**Office of
Environment
& Heritage**

**Re: Young to Wagga Wagga looping pipeline Stage 2 (Bethungra to Young) - Major Project
Application 10_0163**

I refer to the above Major Project Application and accompanying Environmental Assessment ("EA") received by the Office of Environment and Heritage (OEH) on 3 August 2012. OEH has also contacted the consultants that prepared the EA (AECOM Australia Pty Ltd (AECOM)) to discuss some of the issues identified in the EA.

Figures 1A to 1H: TSC and EPBC Box Gum

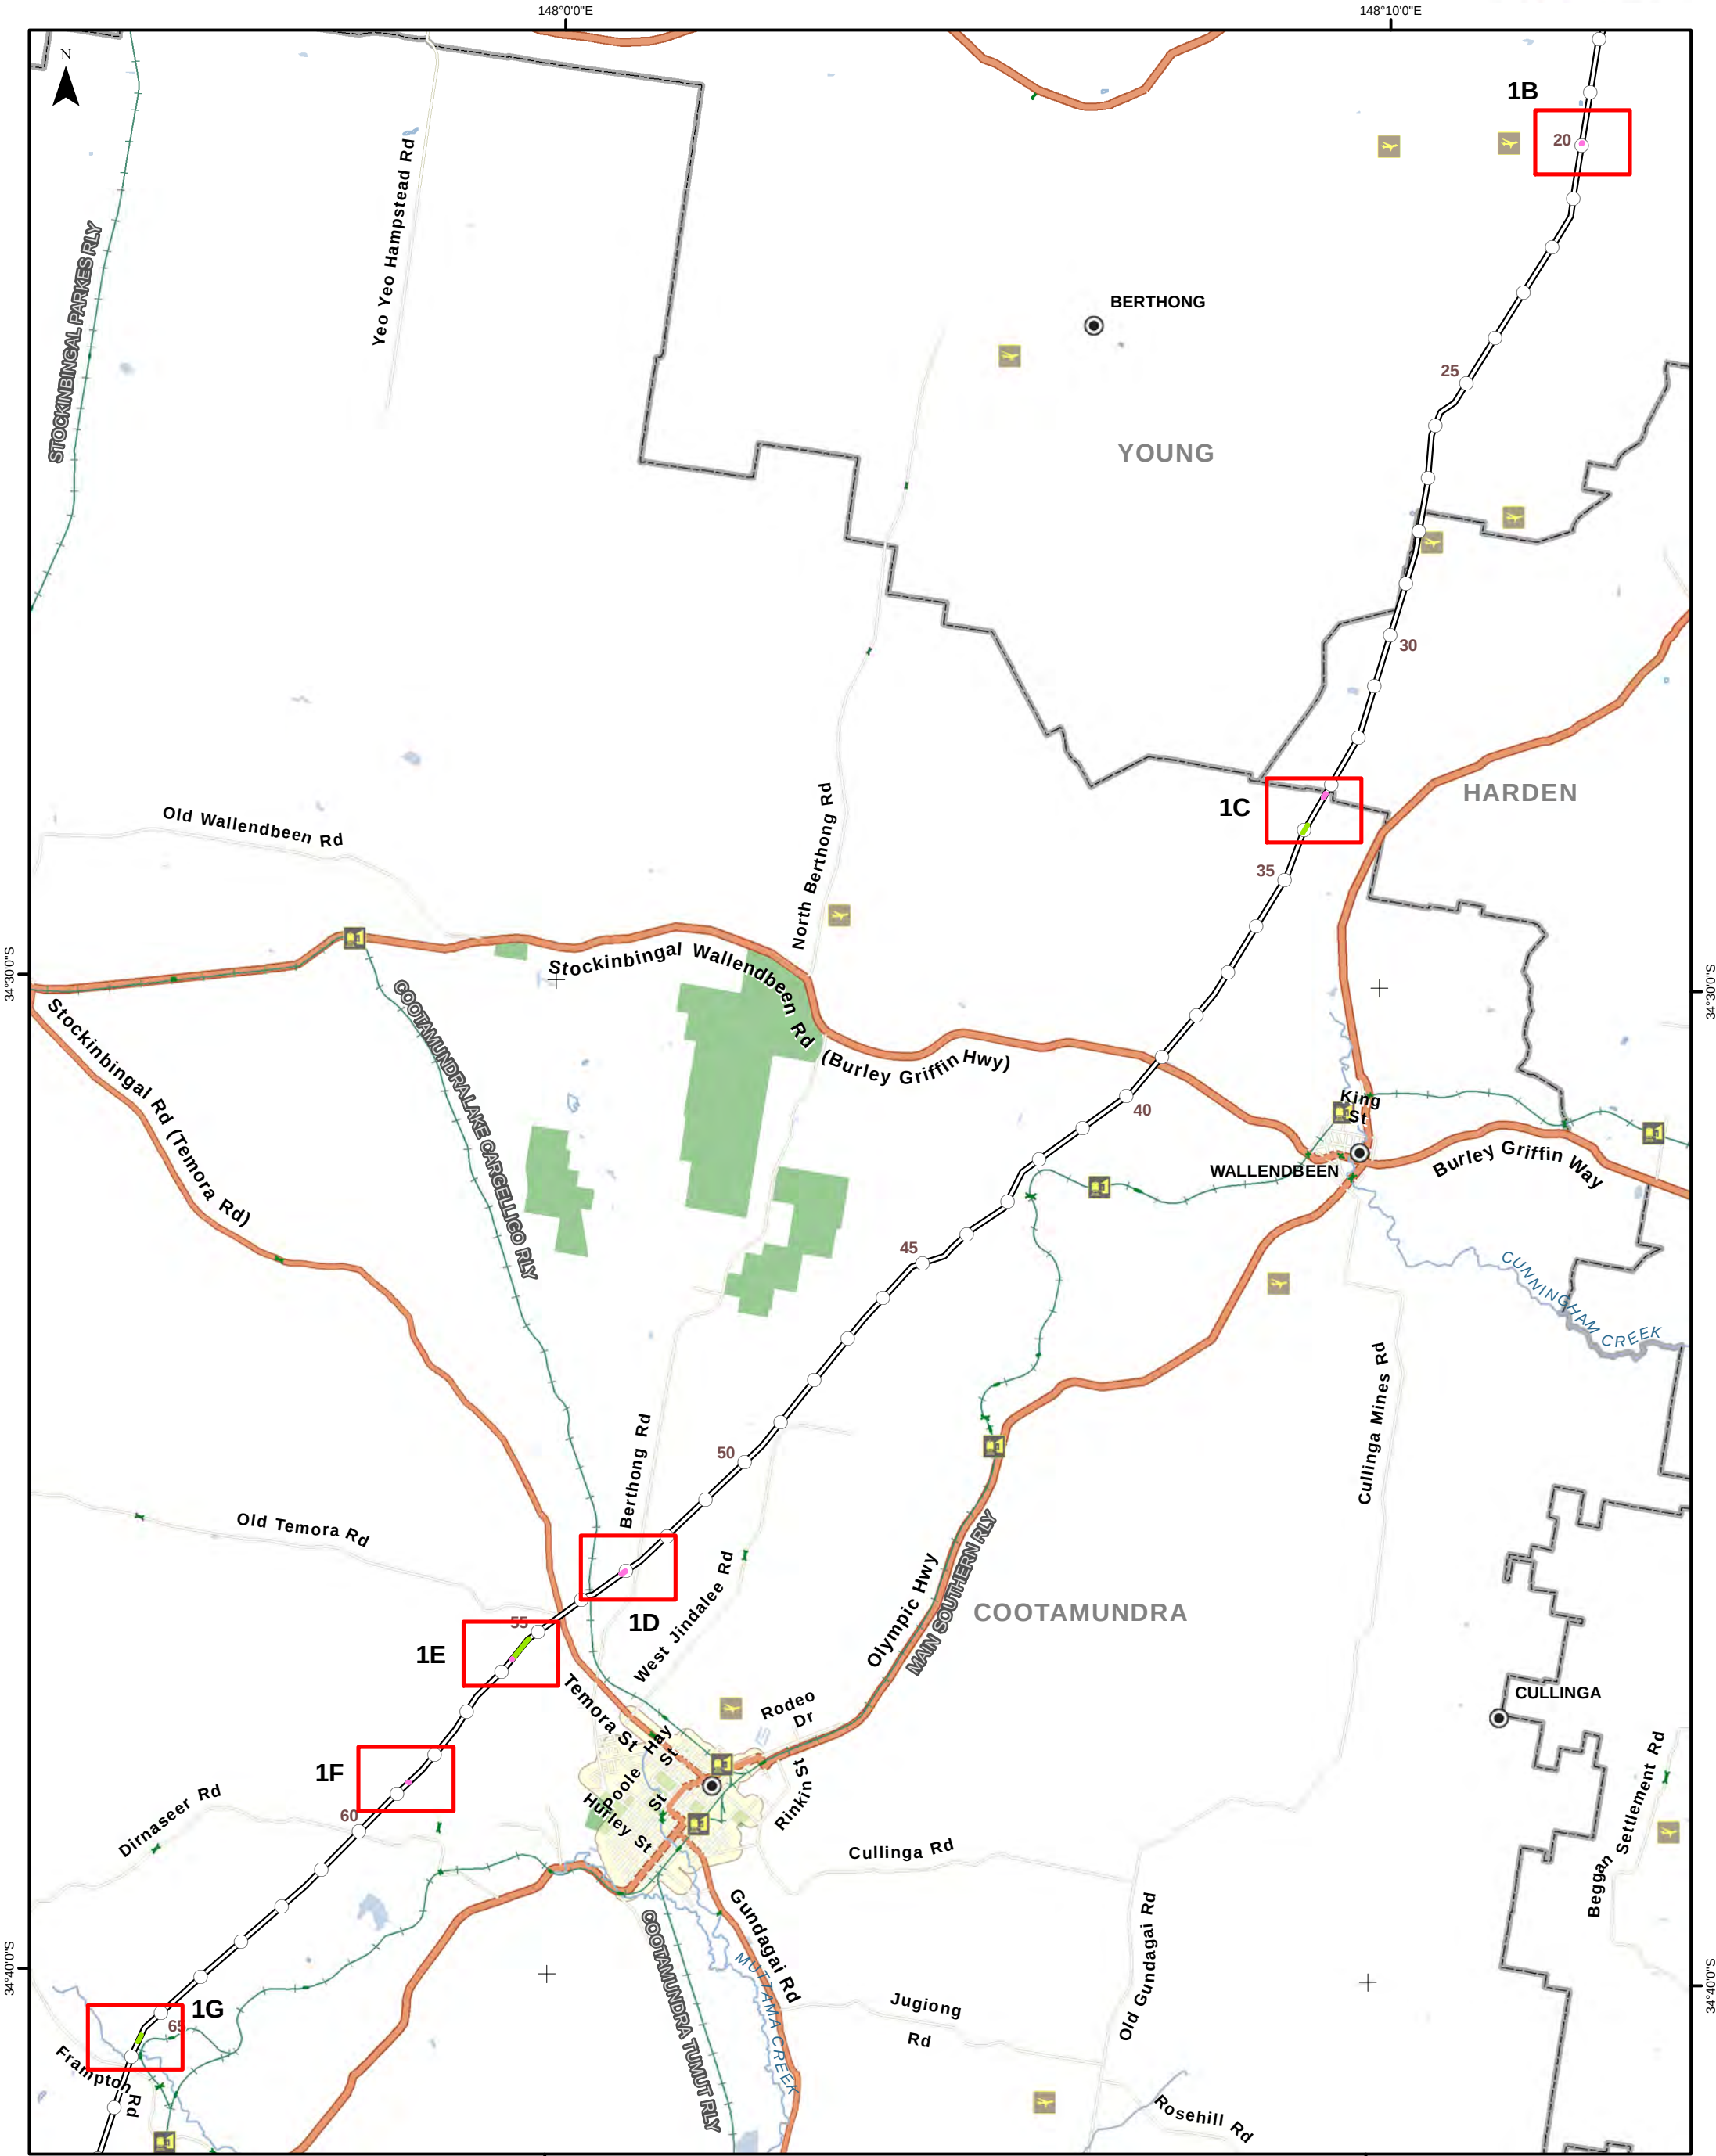
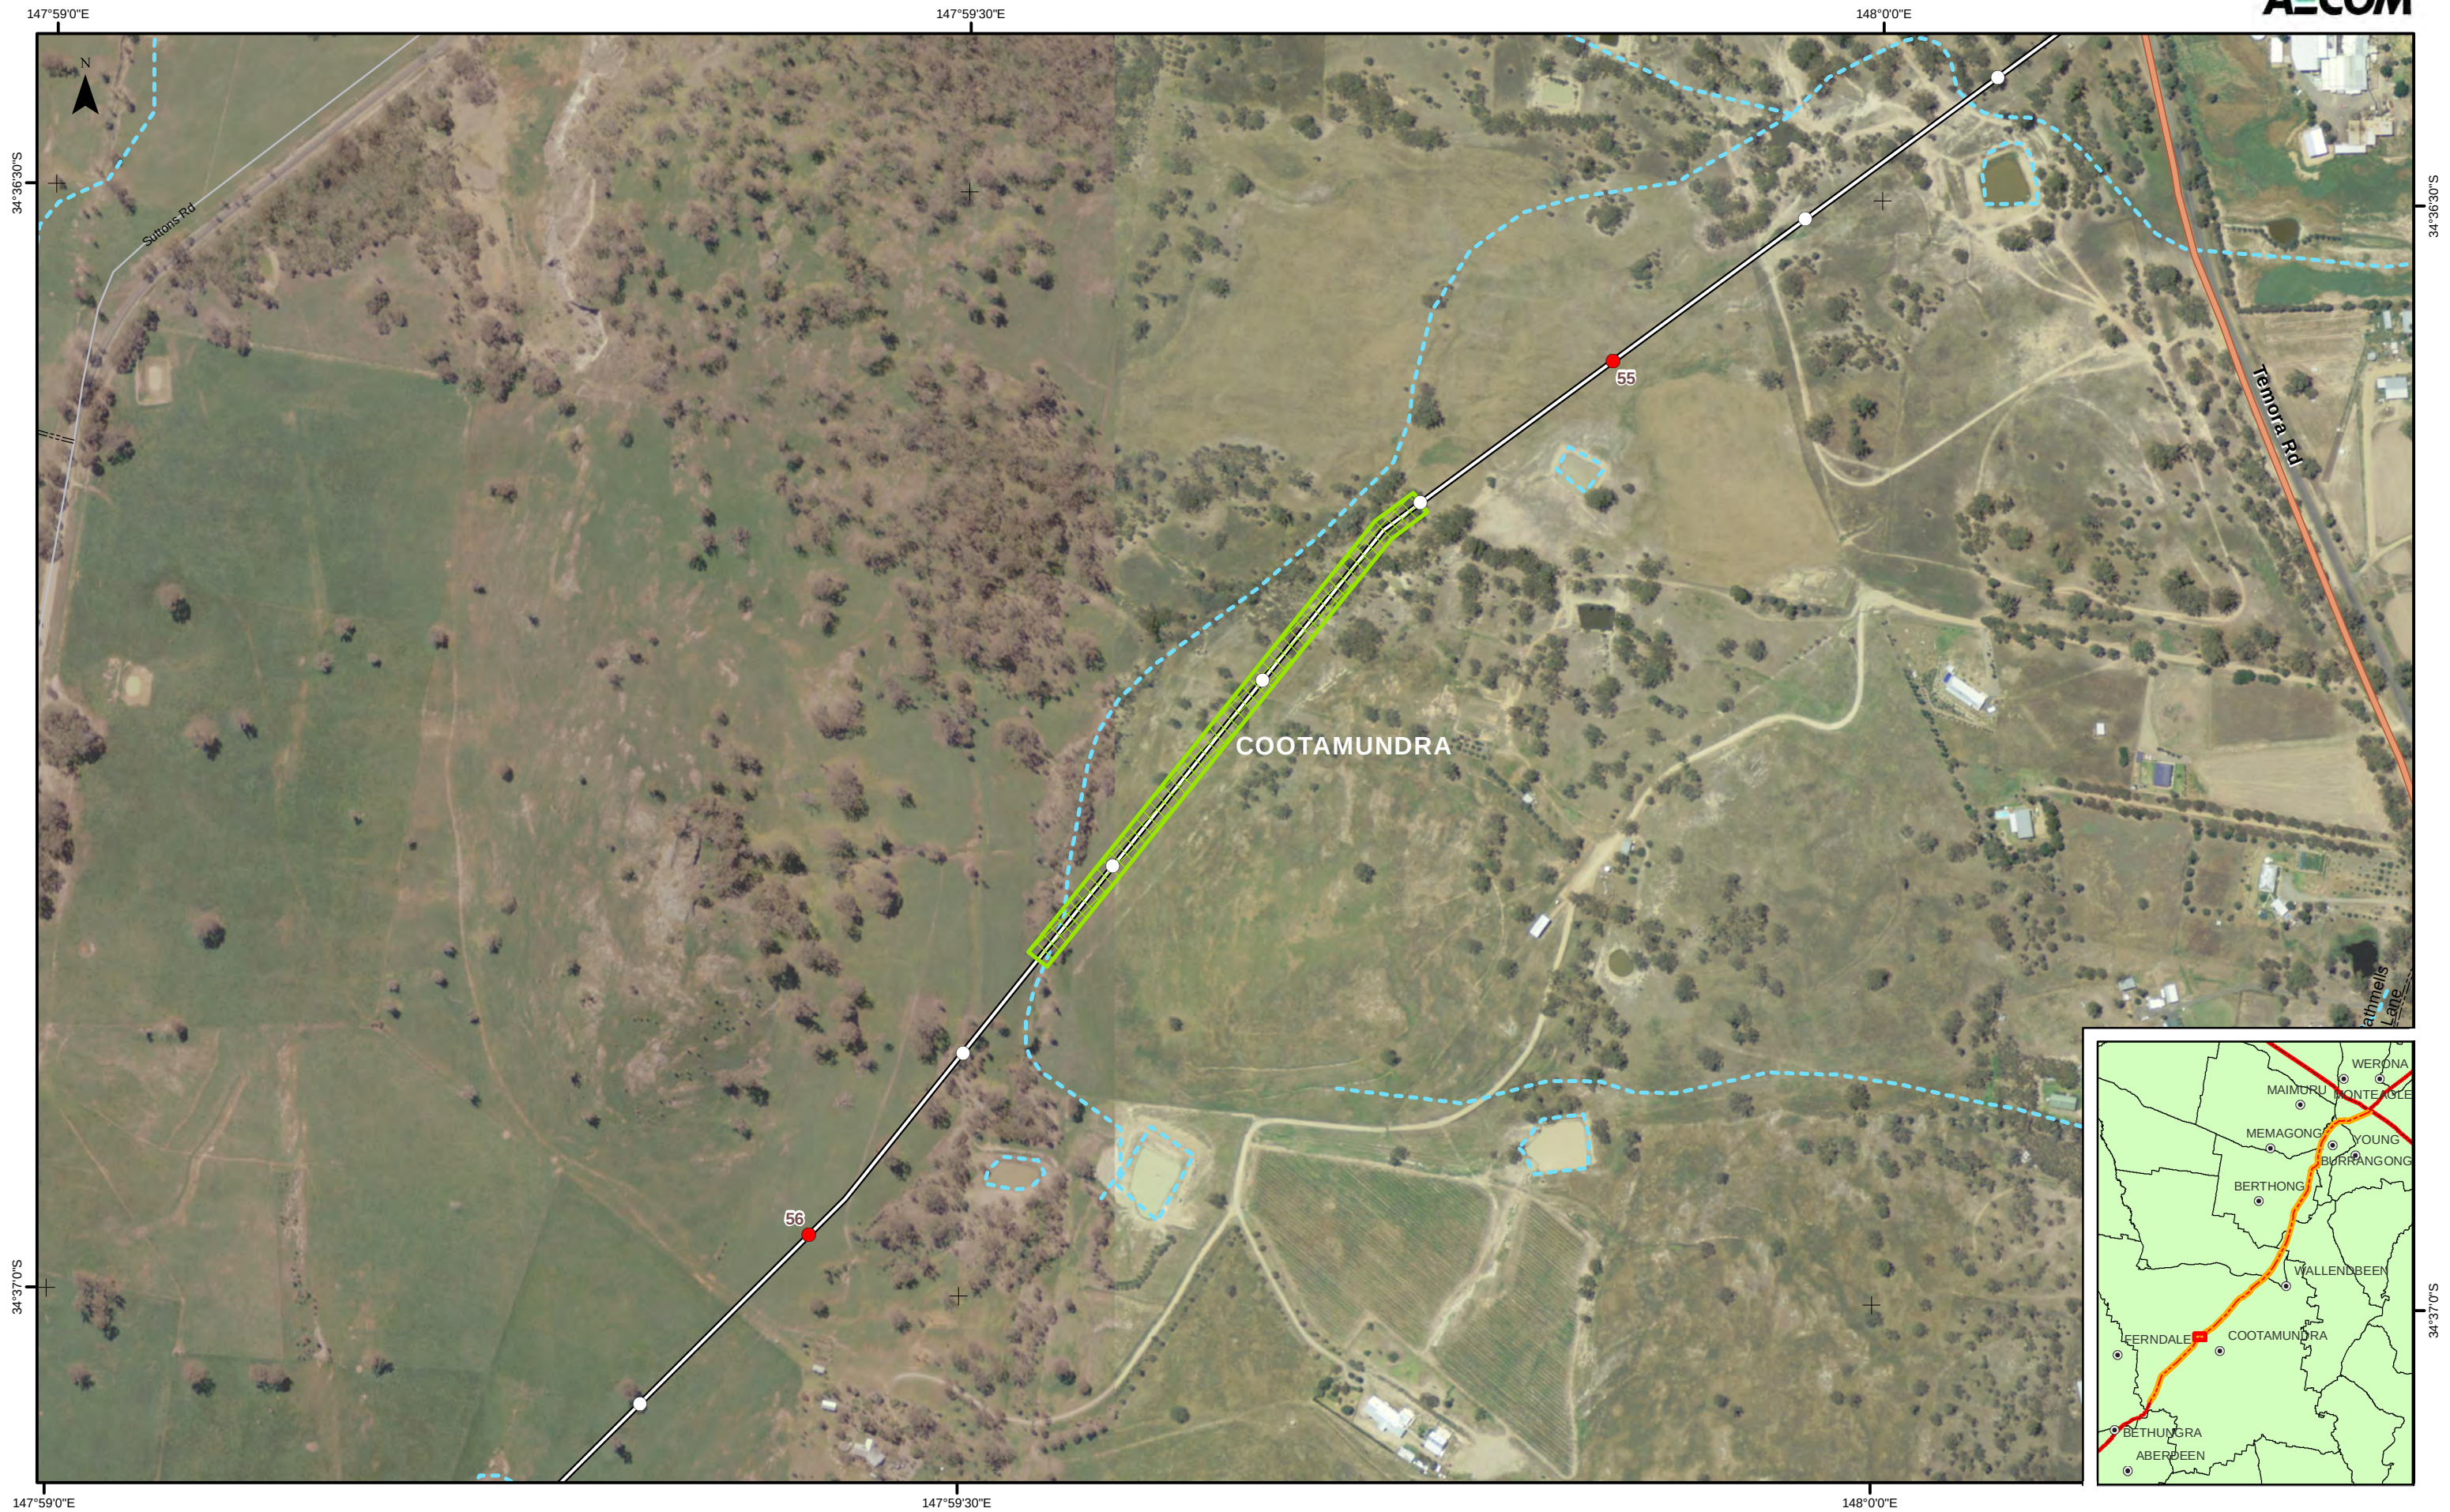
- It is difficult to determine from the EA the overall area of vegetation to be cleared as part of the proposal. The Fauna and Flora Assessment identifies 4.12 hectares of Box-Gum Woodland whereas Table 6 in Appendix A-A identifies 6.96 hectares of remnant vegetation. The location of the additional 2.84 hectares is not identified, as are the communities to be cleared. Additionally, no discussion of the potential existence of grassland derived from Box-Gum Woodland that meet the definition of White Box Yellow Box Blakely's Red Gum Woodland as listed under Schedule 1 of the *Threatened Species Conservation Act 1995* is made in the EA. Subsequent discussion with AECOM have confirmed that the additional area has neither been mapped or identified, though at least some of the areas are likely to be Red Gum Woodland within creek crossings.
